**From:** Contact Centre (CRM) <contact@ribblevalley.gov.uk>  
**Sent:** 09 December 2024 10:28  
**To:** Planning  
**Subject:** Planning Application Comments - 3/2021/0275 FS-Case-669037779

**Planning Application Reference No.:** 3/2021/0275

**Address of Development:** Land Behind The Dog Inn Market Place Longridge PR3 3RR

Site Section through The Dog Inn, Plot 2 and 36 Darwen Close

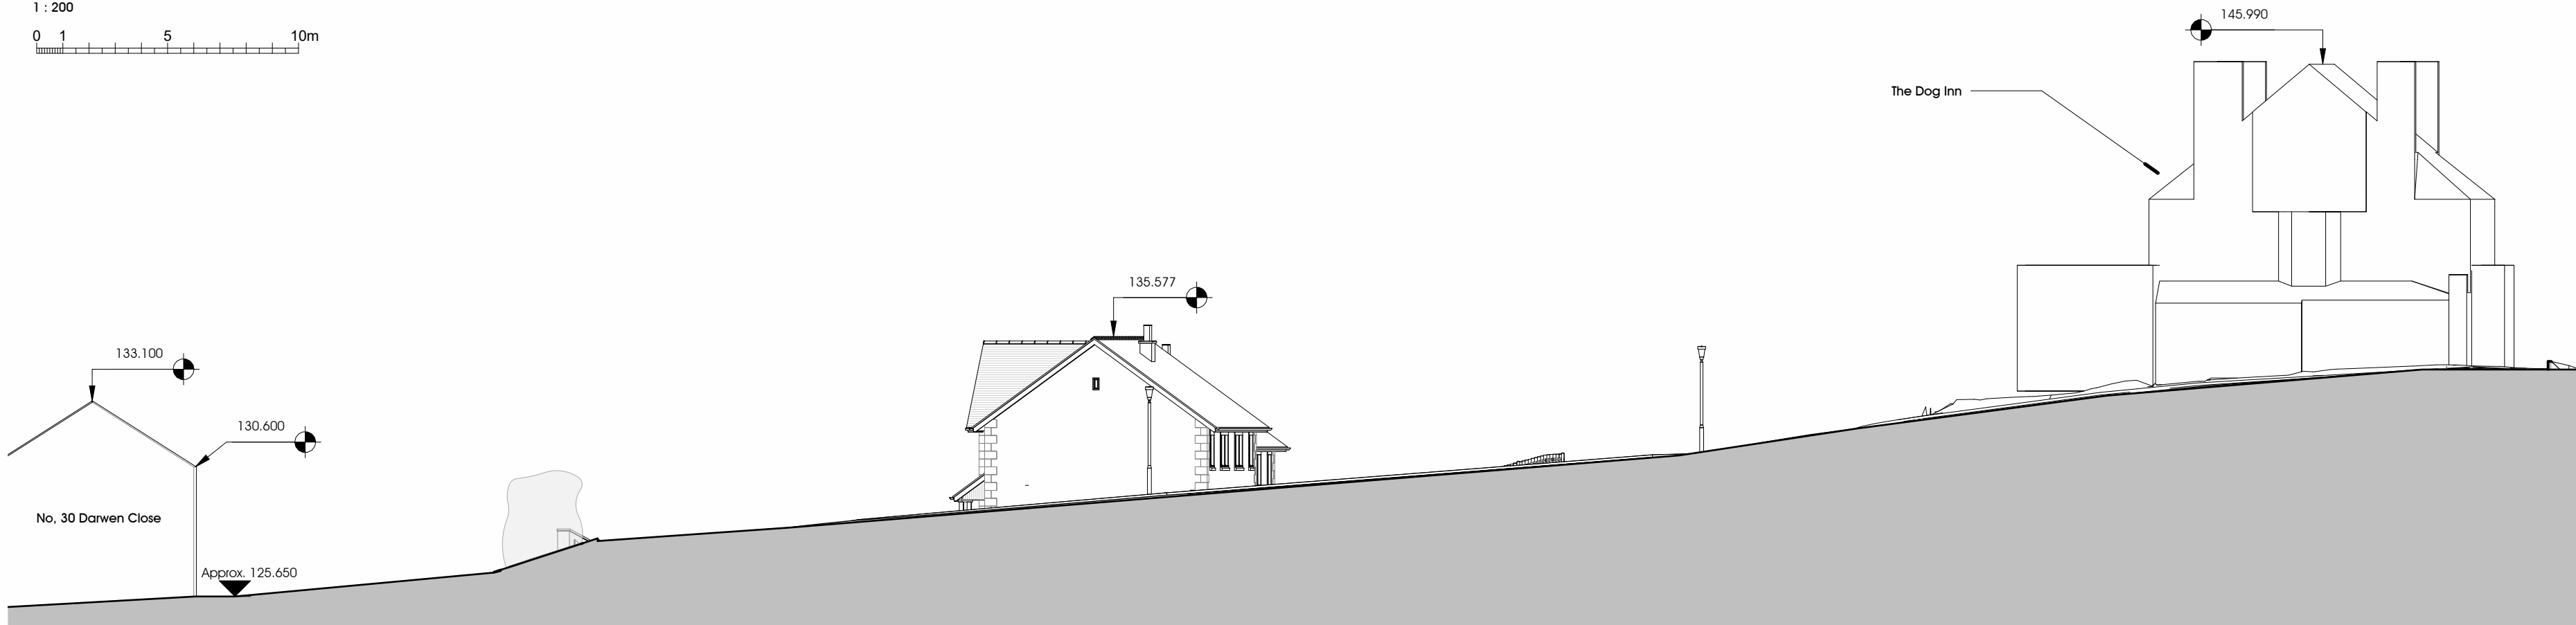
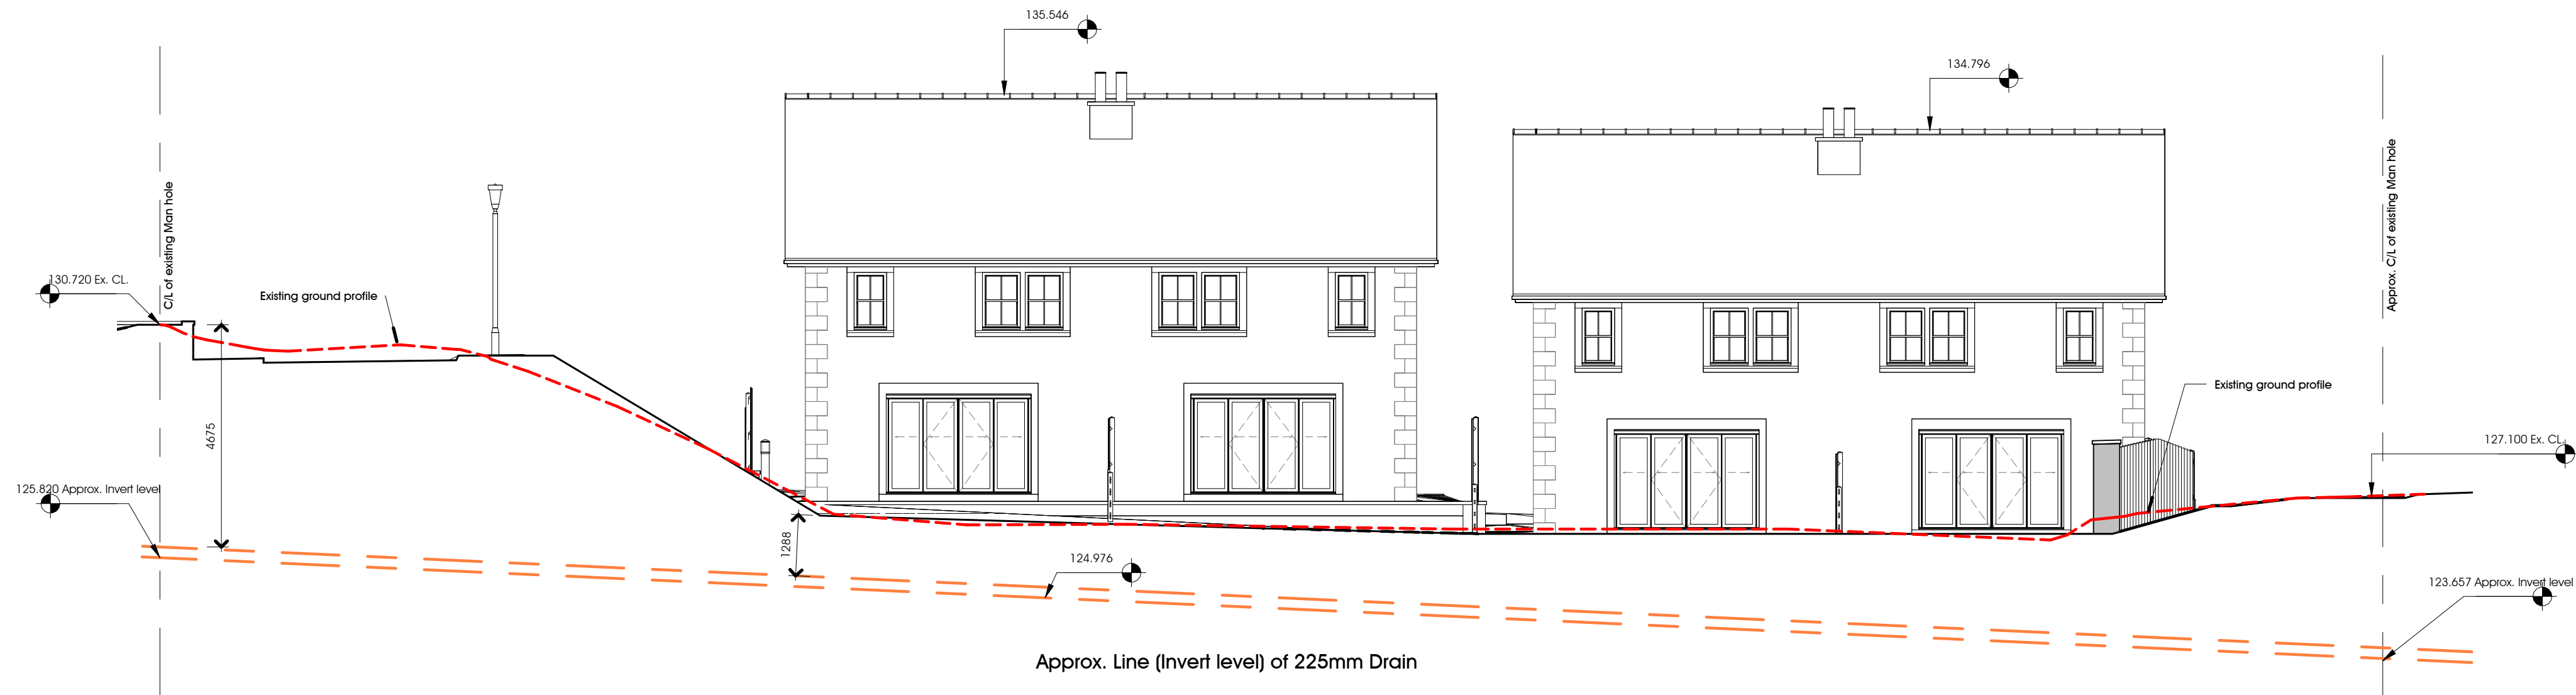
**Comments:** The proposed development is very close to the [REDACTED]  
[REDACTED] As best I can tell the current plan has the proposed property at plot 1 in the region of 1m to 3m  
[REDACTED]; as this building is 8.4m in height I believe this would cause unacceptable  
overshadowing and loss of light.

1. Viewing the plans from the properties on Darwen Close, they show that the proposed development will be imposing to the extreme, due to the height difference of the land. This has always been a concern and with the latest plans there is an increase in the height on the proposed plots 5 to 8, with plot 6 being 0.9m higher than the former plot 4. It is only when [REDACTED] you can appreciate the height difference, as was the case when Longridge Town Councillor [REDACTED] viewed the site in 2022.

2. The first-floor windows in the proposed plot 5 and 6 are significantly higher than [REDACTED]. The height differential is approximately 4m higher [REDACTED], very imposing and [REDACTED].
